Application: SSI 7485

I write regarding the proposed modification to M4-M5 Link, Mod 2 The Crescent overpass and changes to pedestrian infrastructure in North Annandale, Rozelle and Rozelle Bay Foreshore area. *I object to the modifications proposed, and*

Figure 4-2 Pedestrian and cyclist bridge infrastructure options

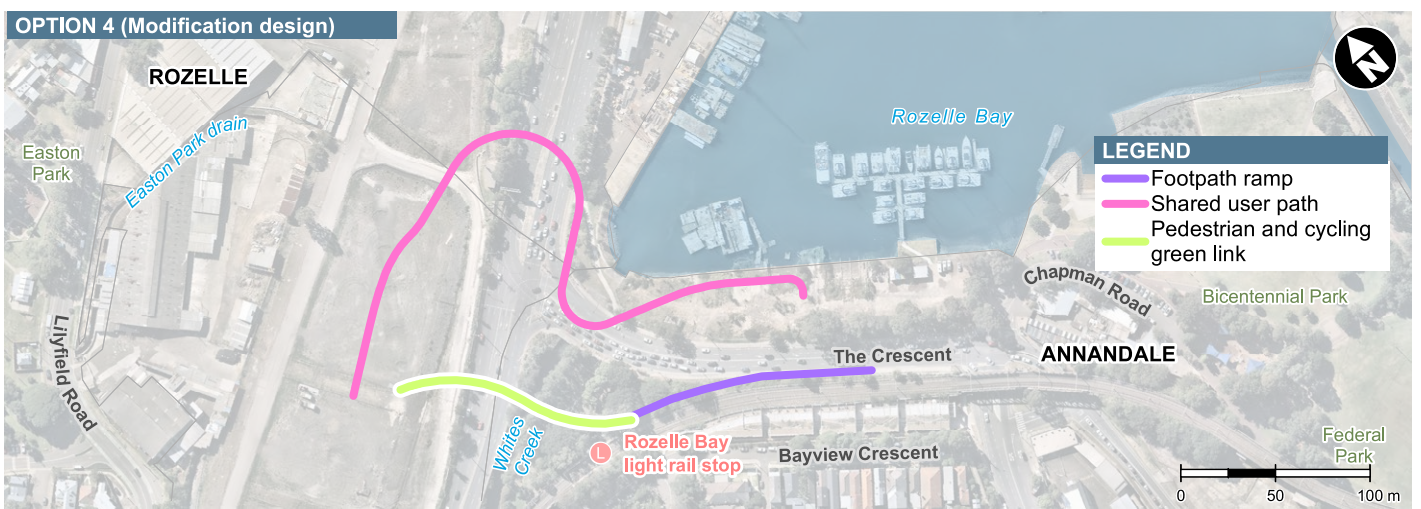
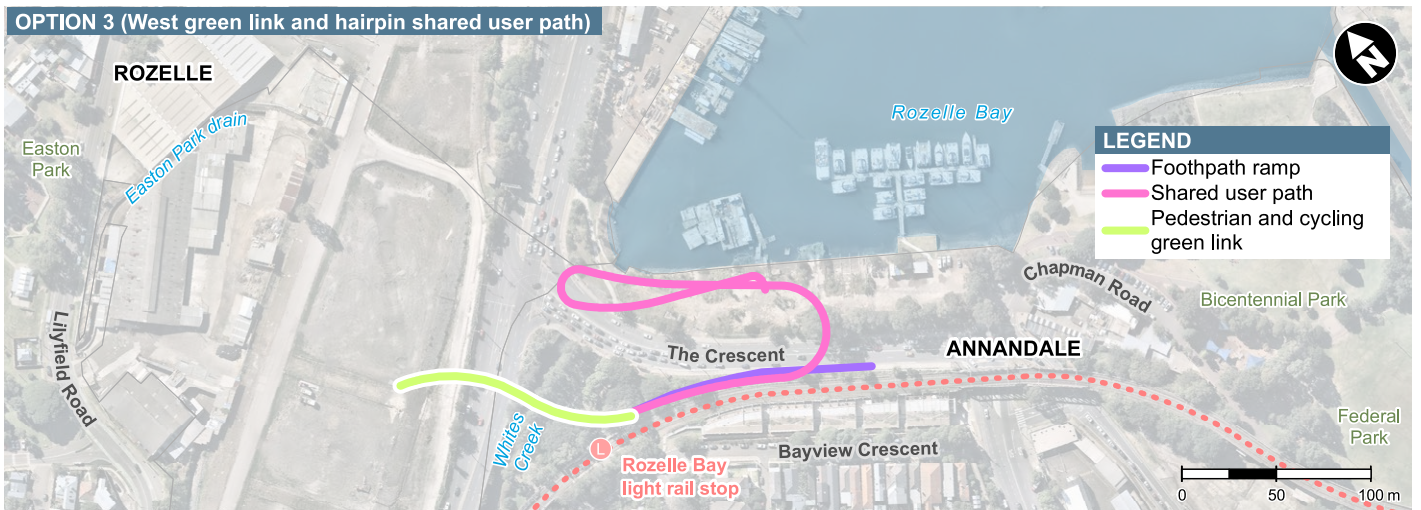
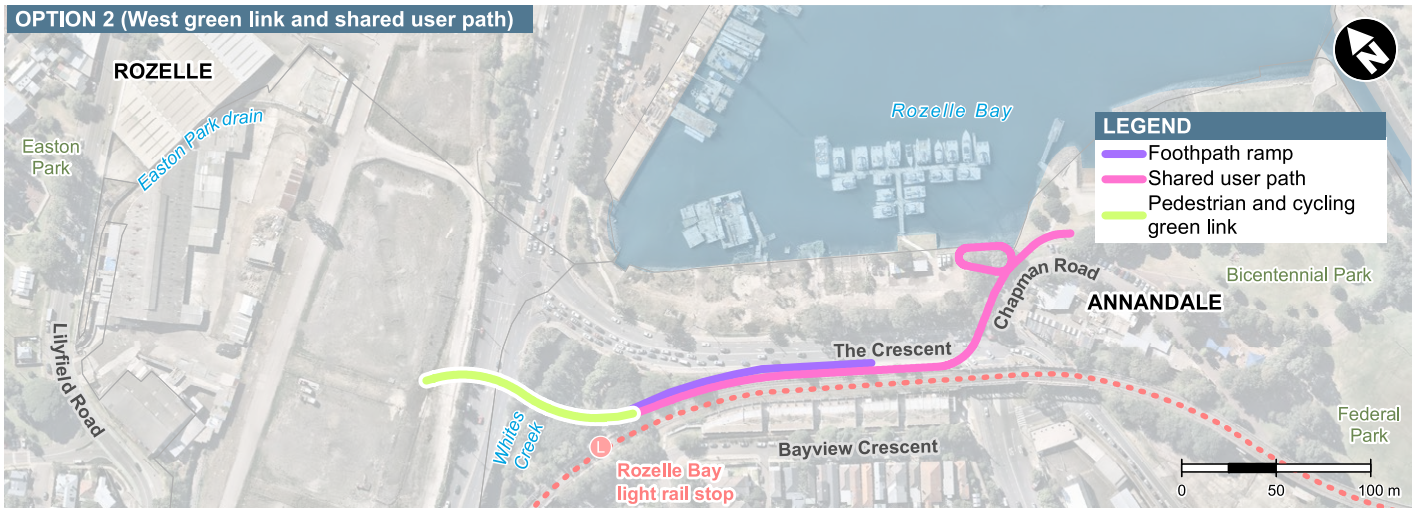
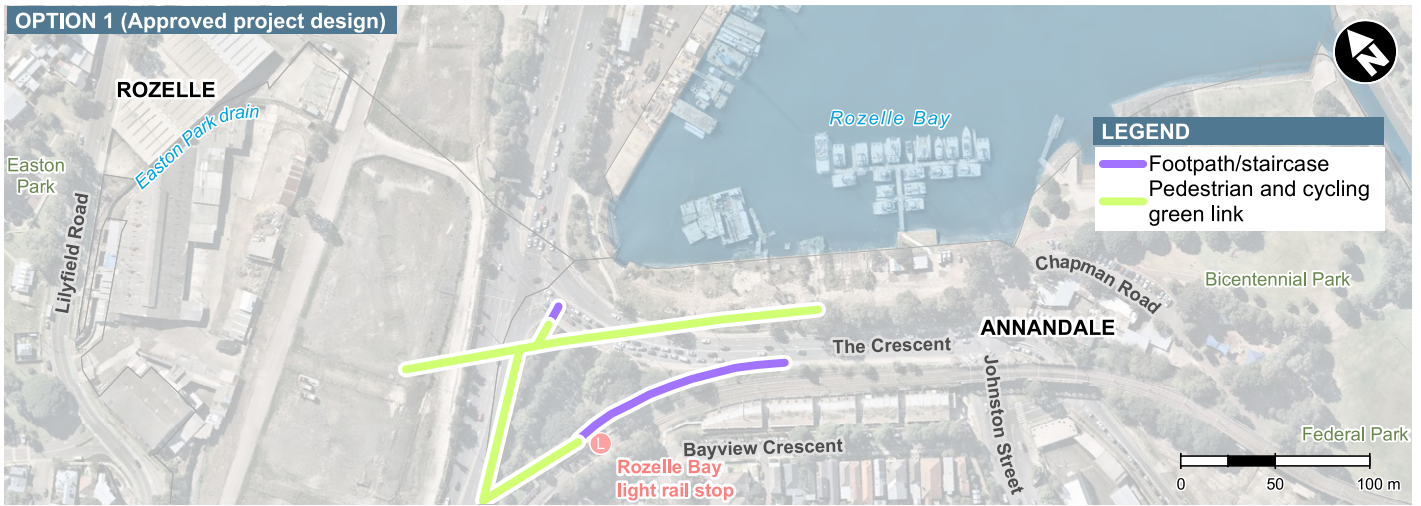
➤ I request RMS work with the community to explore alternate design options to the proposed new car overpass design and the changed pedestrian and cyclist links. I am seeking the reinstatement of the safe, direct access from the approved EIS GreenLink to create a continuous green open space connection from the Rozelle Rail yards and Annandale to the foreshore. The GreenLink was more than just a walk way - it put people central to the design, maximising safety, and providing much needed accessible open space for the community now and into the future Bays Precinct design.

- The significantly reduced safety and increased risk for pedestrians and cyclists with removed access over The Crescent to Bicentennial Park and the increased traffic along Johnson Street.
- Being required to cross five sets of pedestrian lights at The Crescent as my option to reach the foreshore from Annandale or from Rozelle Bay light rail stop.
- Removal of direct active links to the foreshore, cutting the community off from the area and the proposed revitalisation of the entire Bays Precinct, including linking the Light Rail and Bus stops to a Ferry wharf and Metro station.
- Urban and landscape design that is being built before a finalised Masterplan for the area.
- Traffic changes that limit movements around the suburb and create further congestion in the local streets of Annandale, Forest Lodge, Glebe, Lilyfield and Rozelle with no planning to deal with these.

- Reinstate the GreenLink connecting communities and green open space from Rozelle to Bicentennial Park
- Relocate and design pedestrian and cyclist connections that are continuous, safe and direct.
- Design the modification infrastructure and active links in response to the character of the suburbs, the location of the foreshore and it's potential future development.
- Provide pedestrian and cyclist paths that maximise people safety and do not force them onto busier streets, unsafe concrete plazas and caged walkways.
- Integrate active and direct connections to all active transport – including the future Metro West and Foreshore Ferry Wharf

Figure 4-4 Elevation: Indicative view of The Crescent overpass

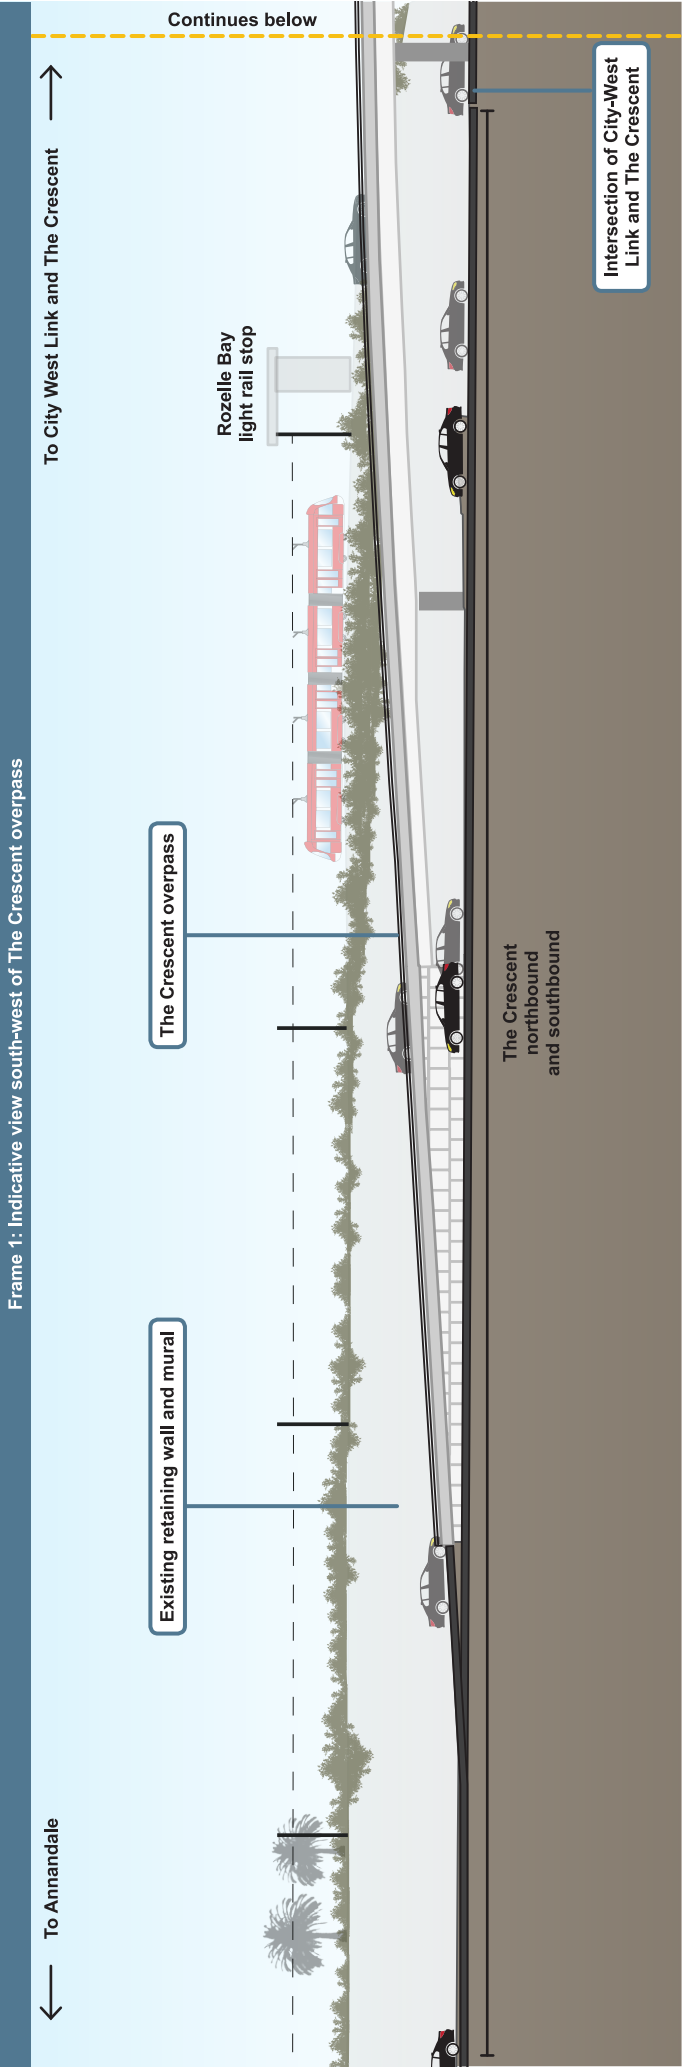
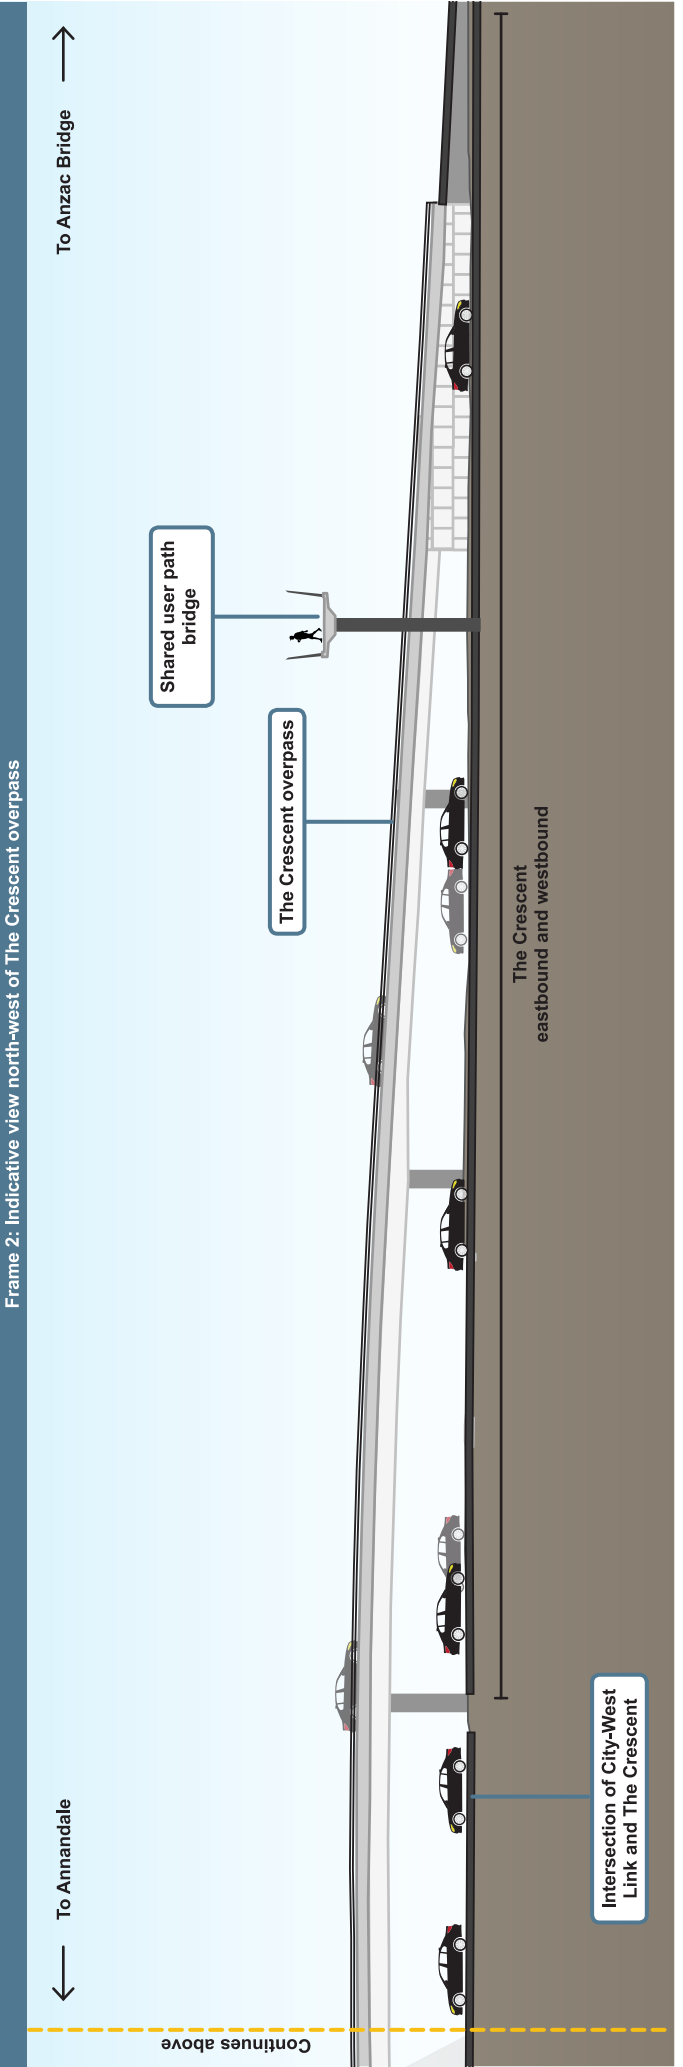
The design is also completely at odds with the heritage look + feel of the area will damage the character and outlook of the surrounding area.
